Pymble Ladies College - Grey House Precinct (SSD-17424905)

Response to Submissions

Attachment A–Key Issues

SHADOW DIAGRAMS -
SHEET 3

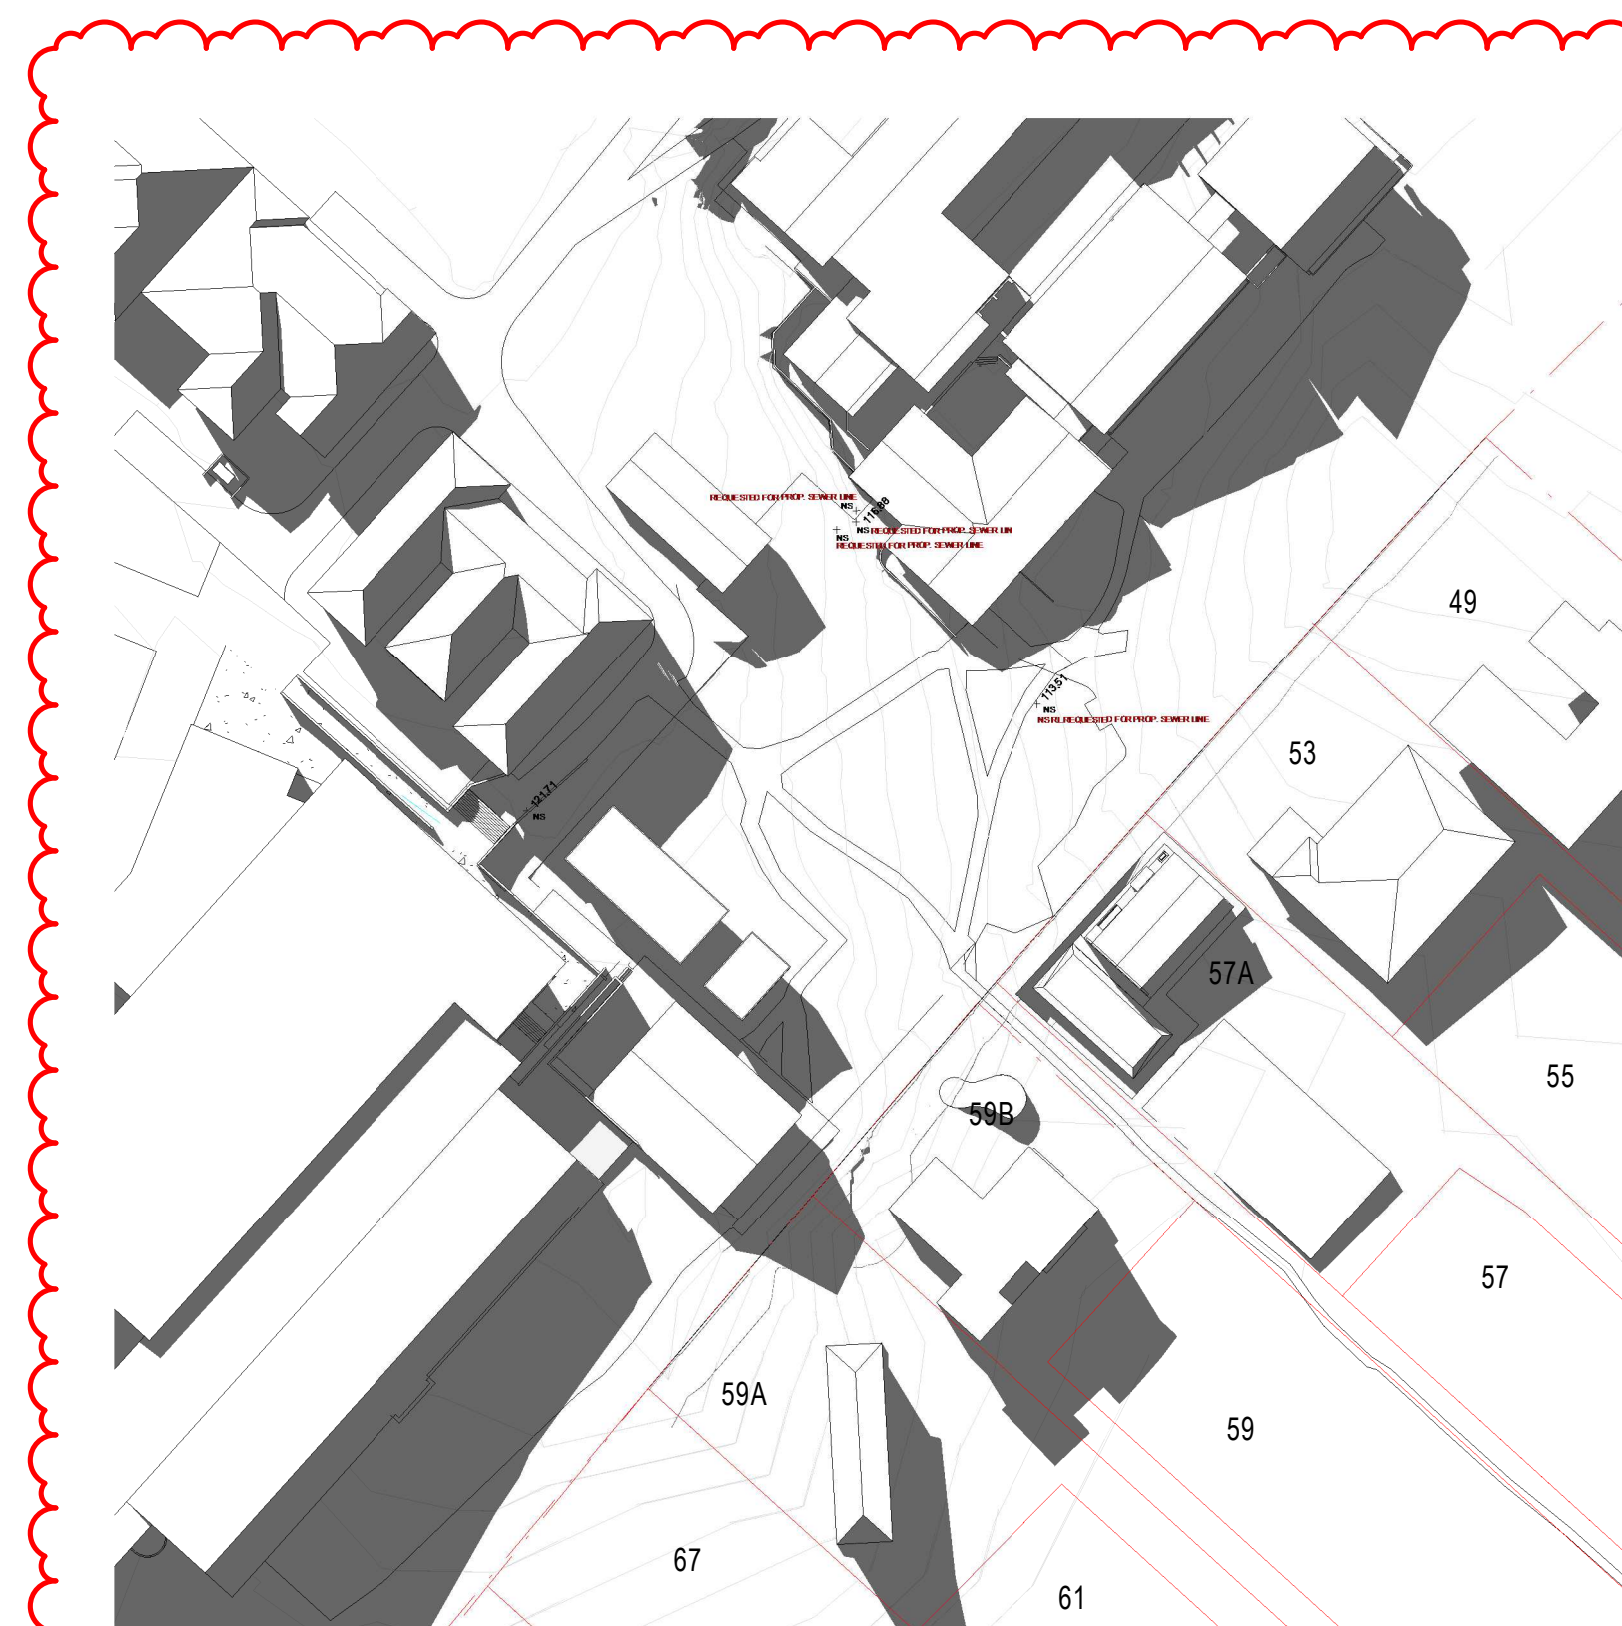
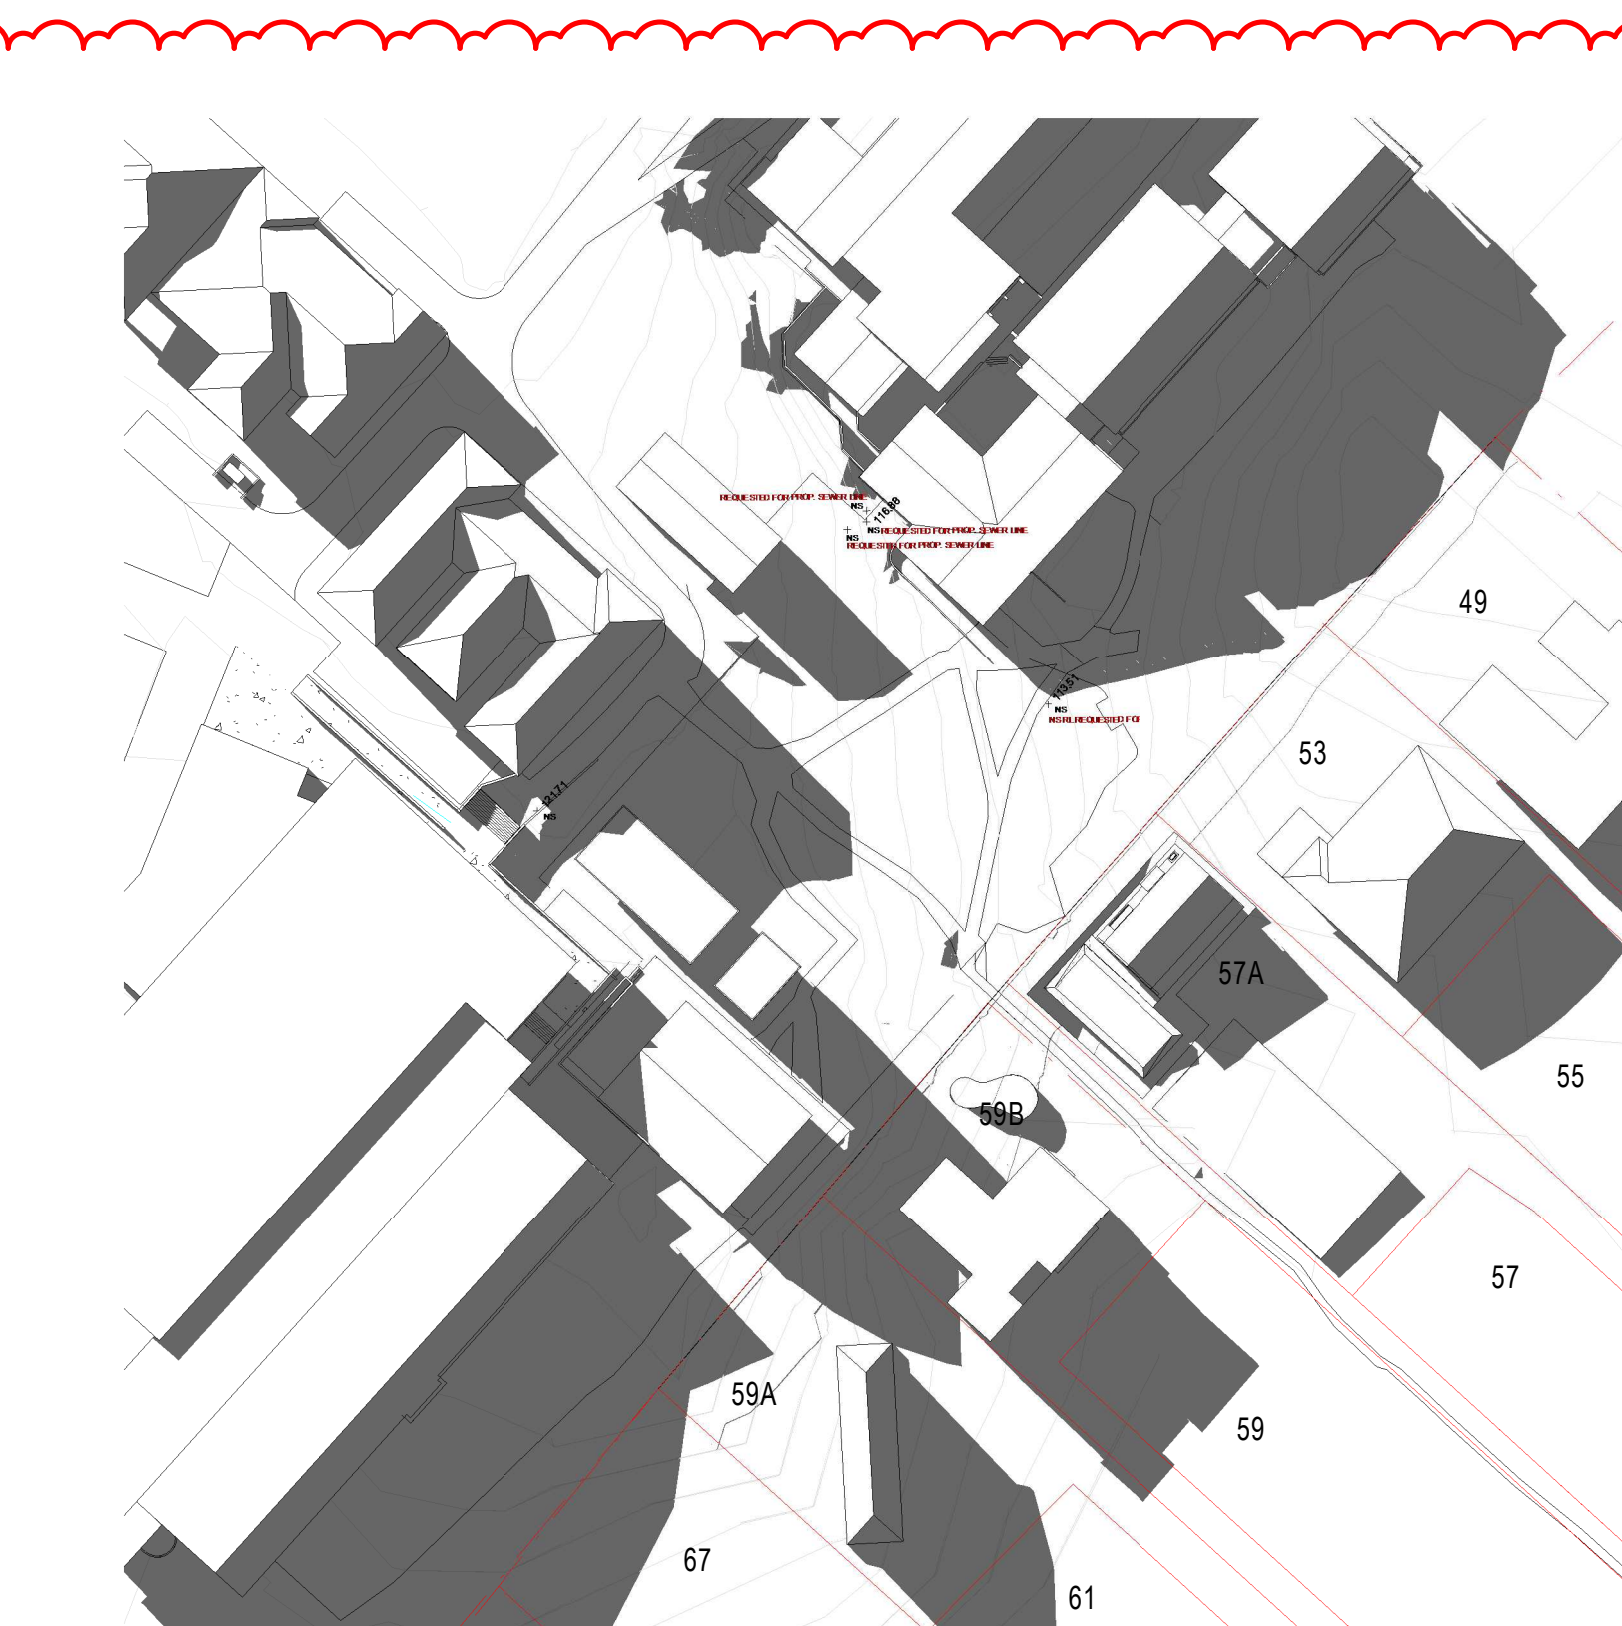
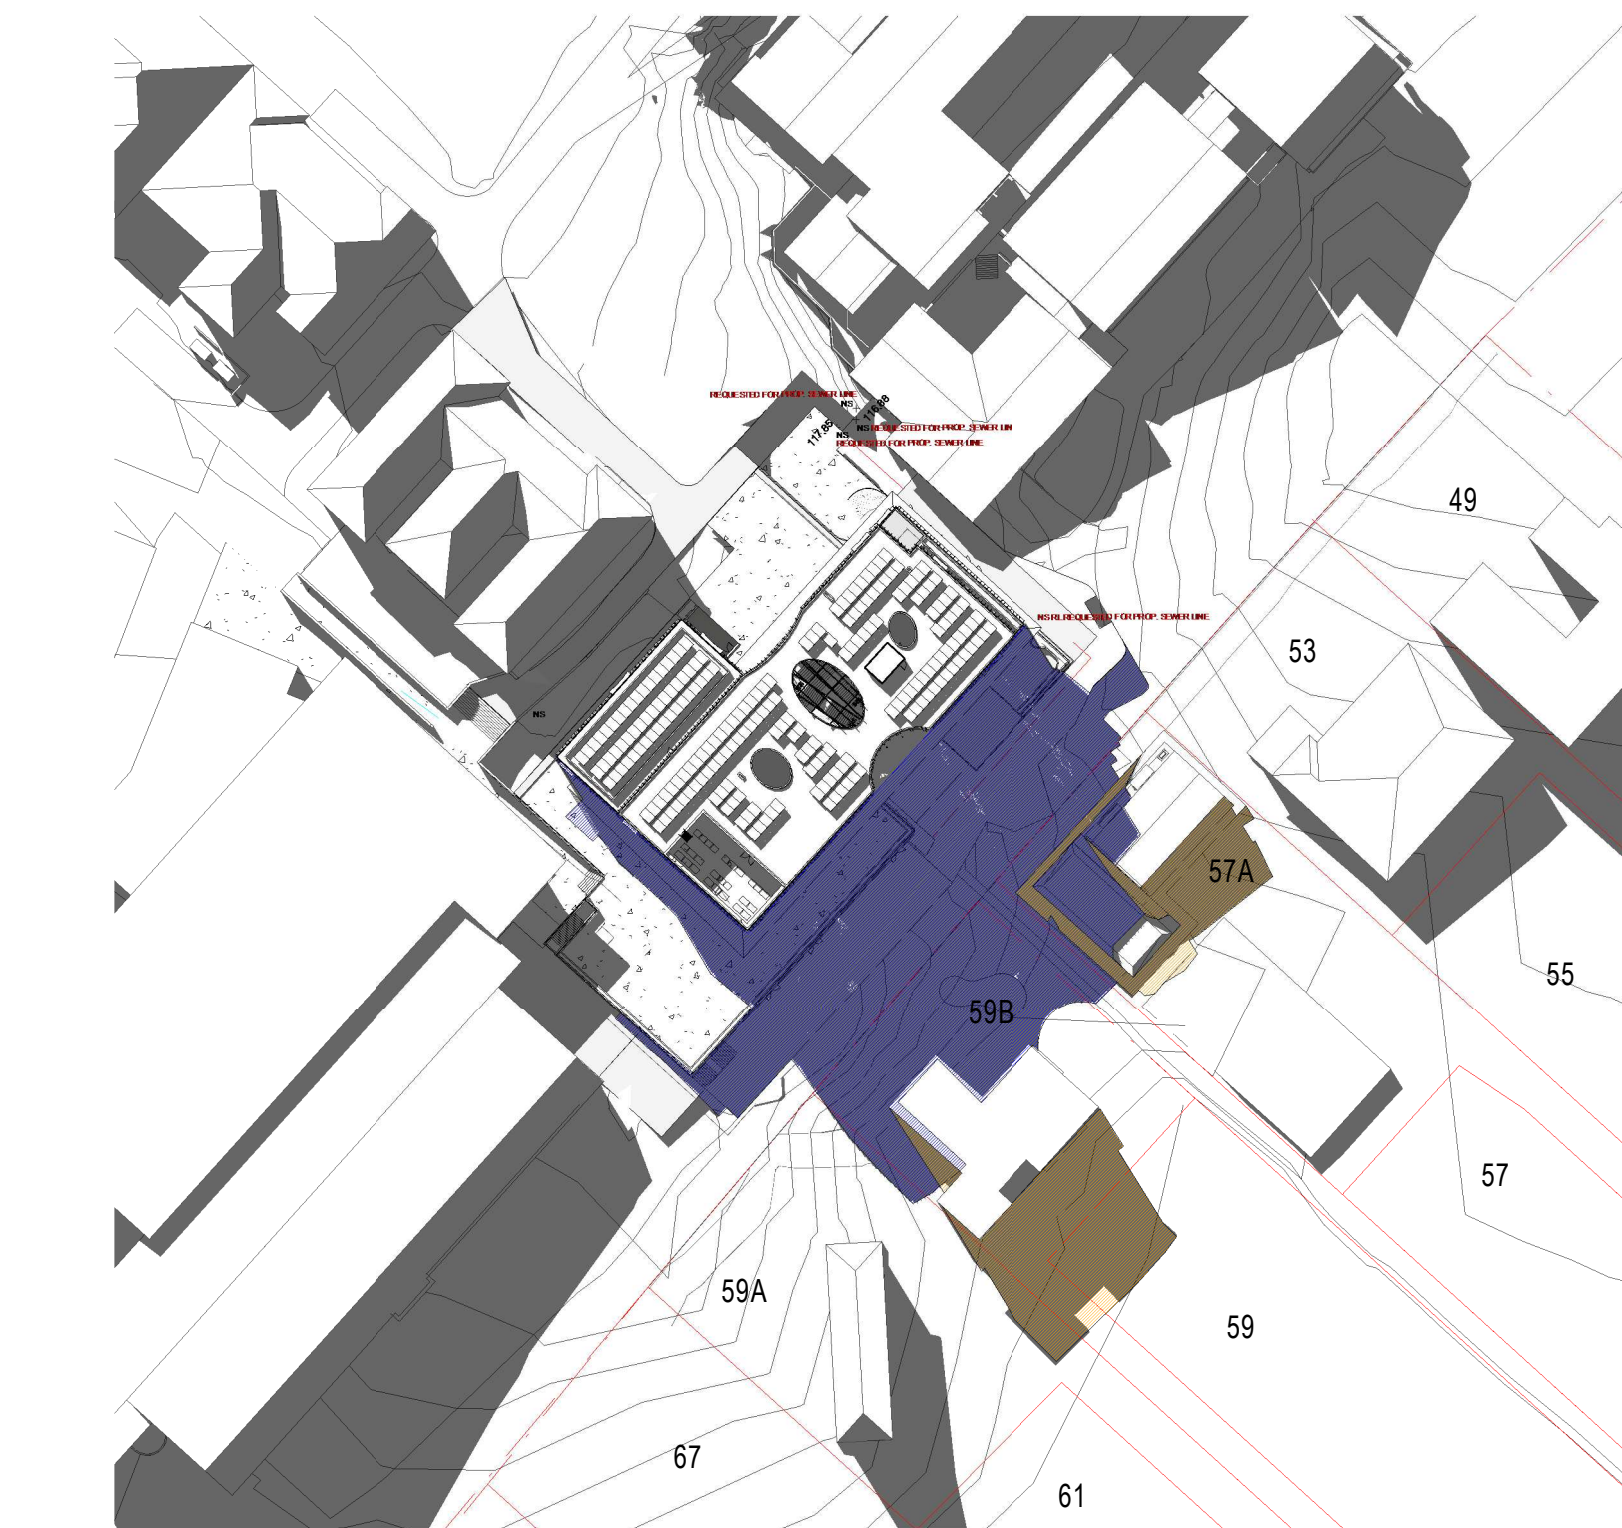
2. According to the Ku-ring-gai Development Control Plan, a building should be sited to maintain solar access to north facing windows and rear yards of adjoining properties of at least four hours between 9am and 3pm on 21st June. The proposed development does not comply with this requirement. Please address this issue and demonstrate how the development would maintain an appropriate level of solar access to the impacted properties (to its south) during winter solstice.
